SUBJECT: Engineering Review Comment
Mountain View Electric Association Inc. (MVEA)

Project Name: Graupner Subdivision

Project Number: MS237

Description: Proposed development of 4 residential lots on approximately 41 acres located west of Eastonville Rd. and north of Murphy Rd. in Township 11S, Range 64W, Section 32.

GRAUPNER SUBDIVISION

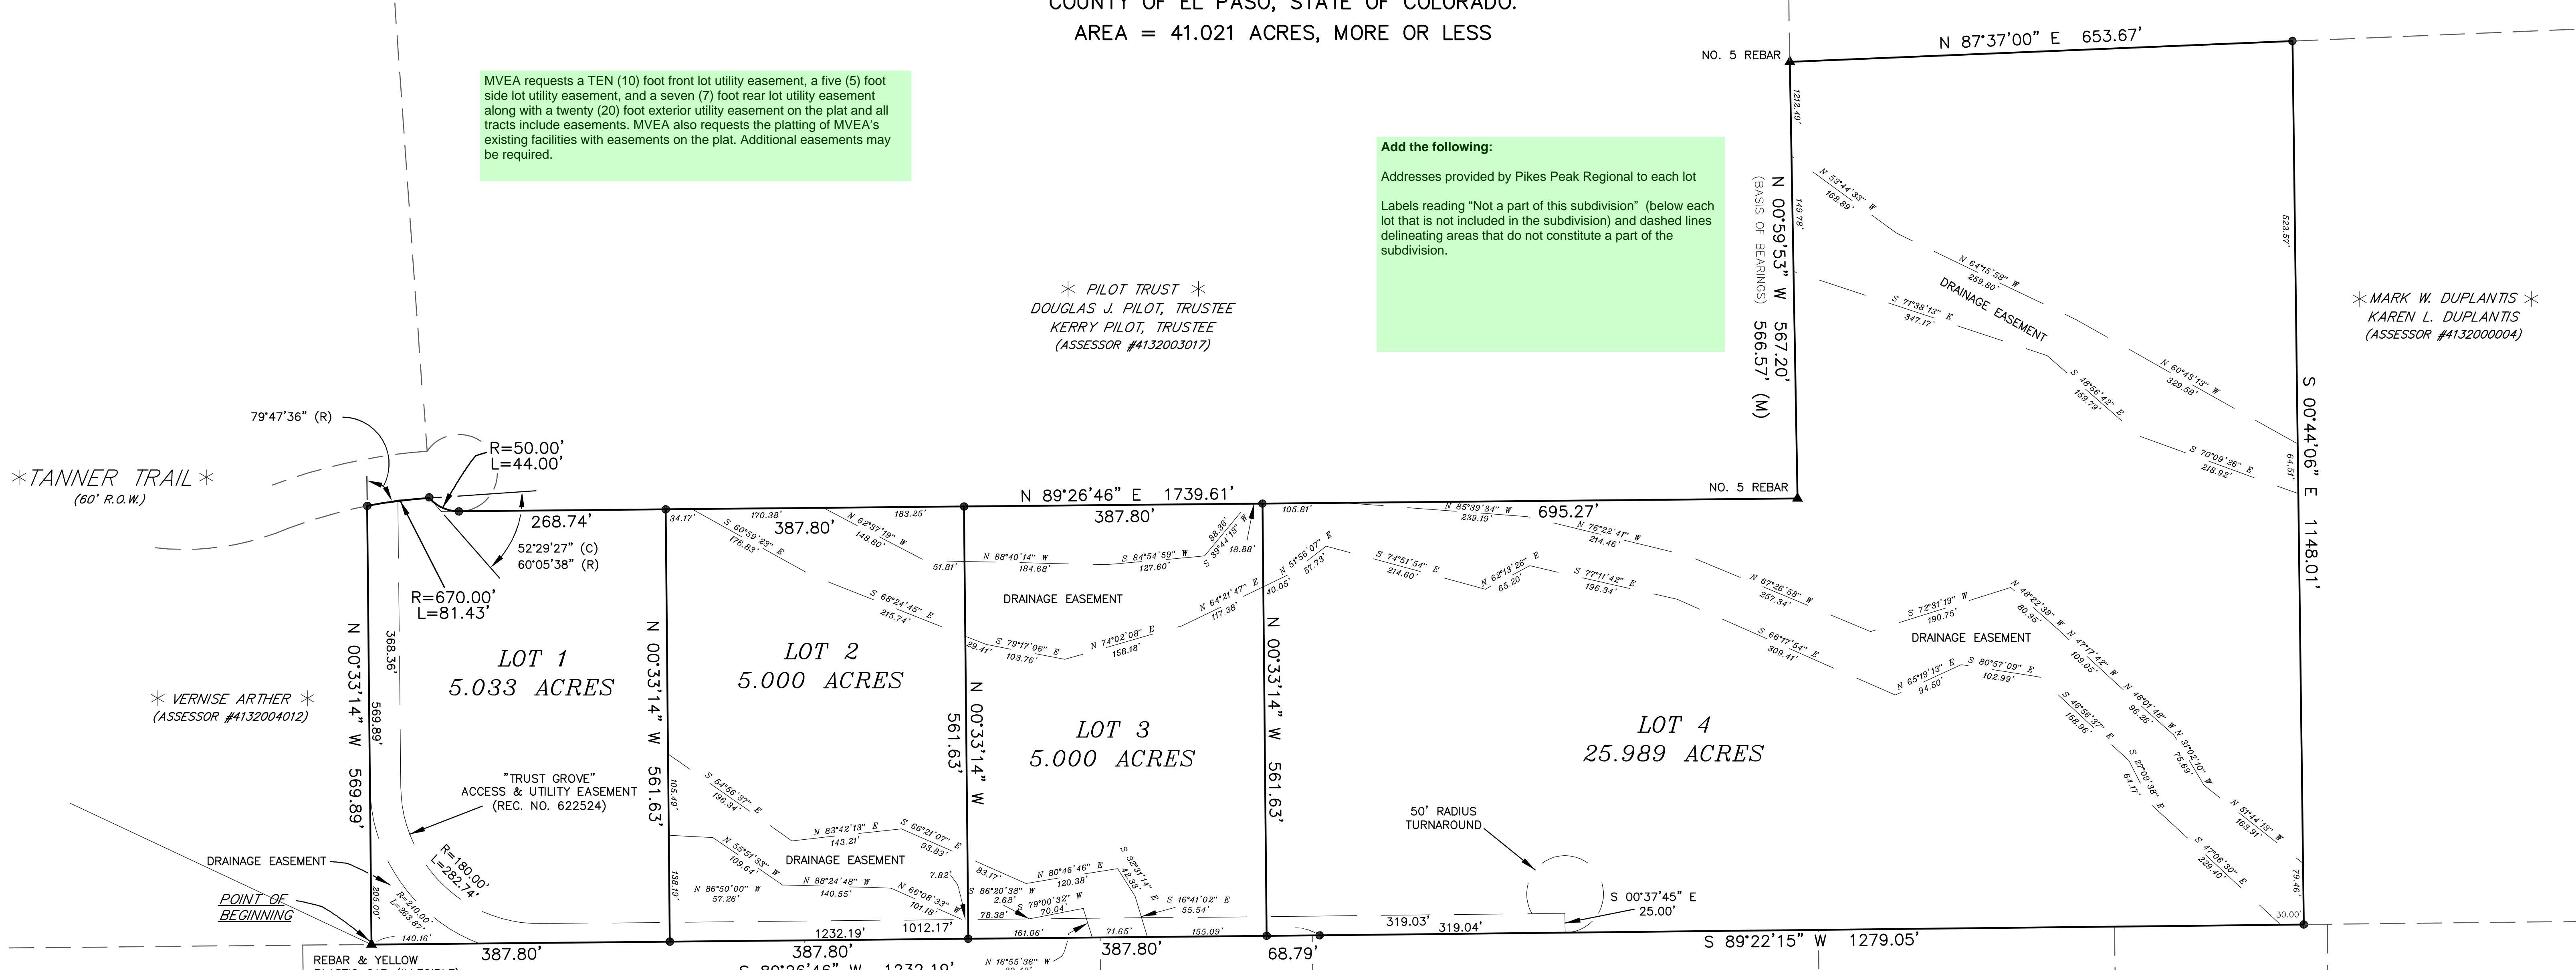
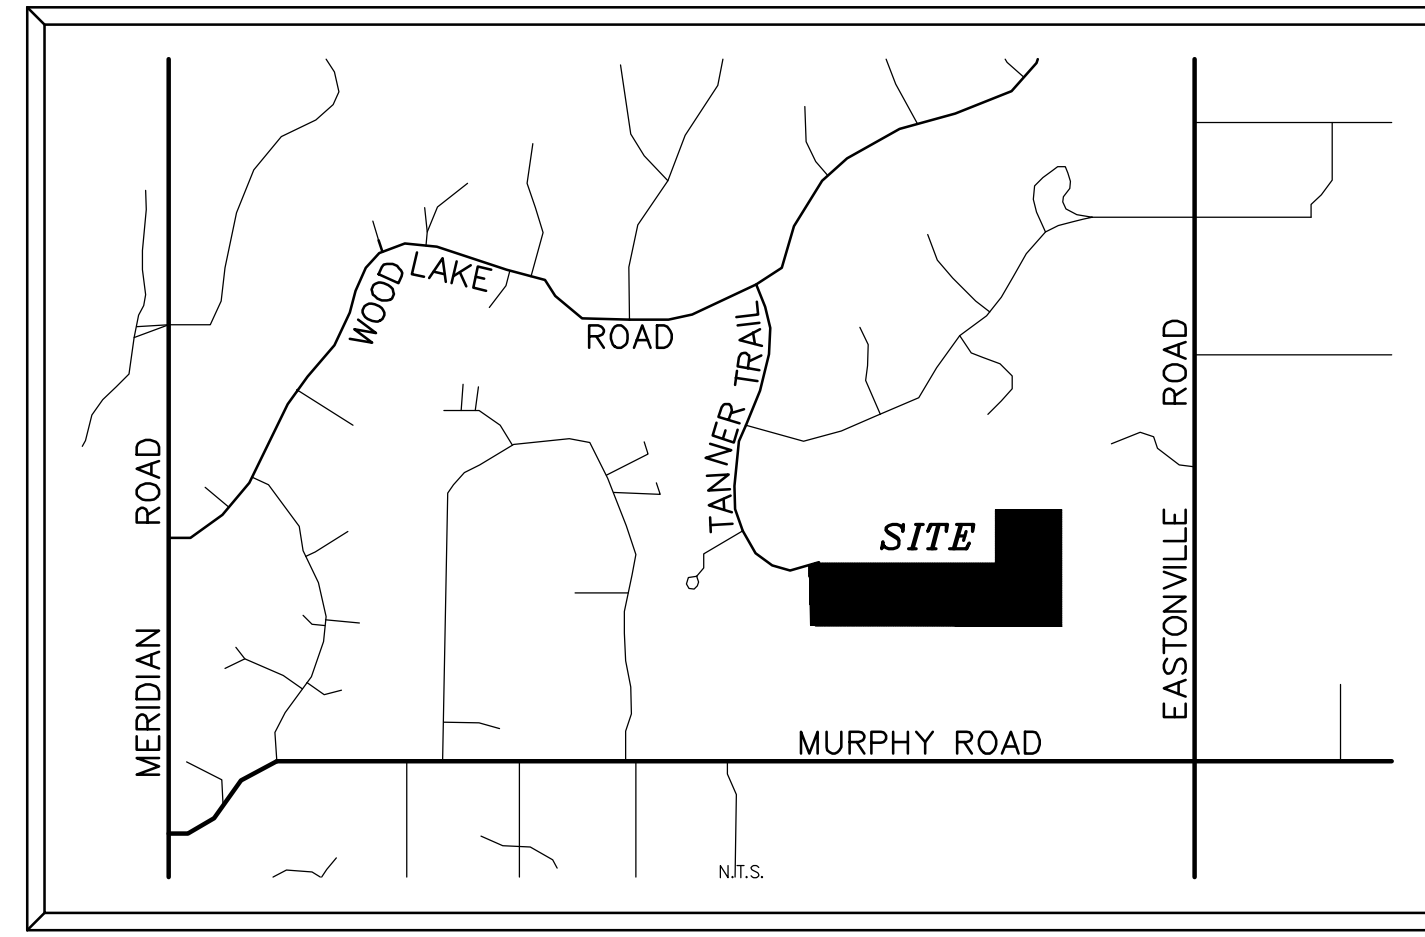
MVEA requests a ten (10) foot front lot utility easement, a five (5) foot side lot utility easement, and a seven (7) foot rear lot utility easement along with a twenty (20) foot exterior utility easement on the plat and all tracts include easements. MVEA also requests the platting of MVEA's existing facilities with easements on the plat. Additional easements may be required.

MVEA has existing facilities near and within this parcel of land. If there is any damage, removal or relocation of facilities it will be at the expense of the applicant.
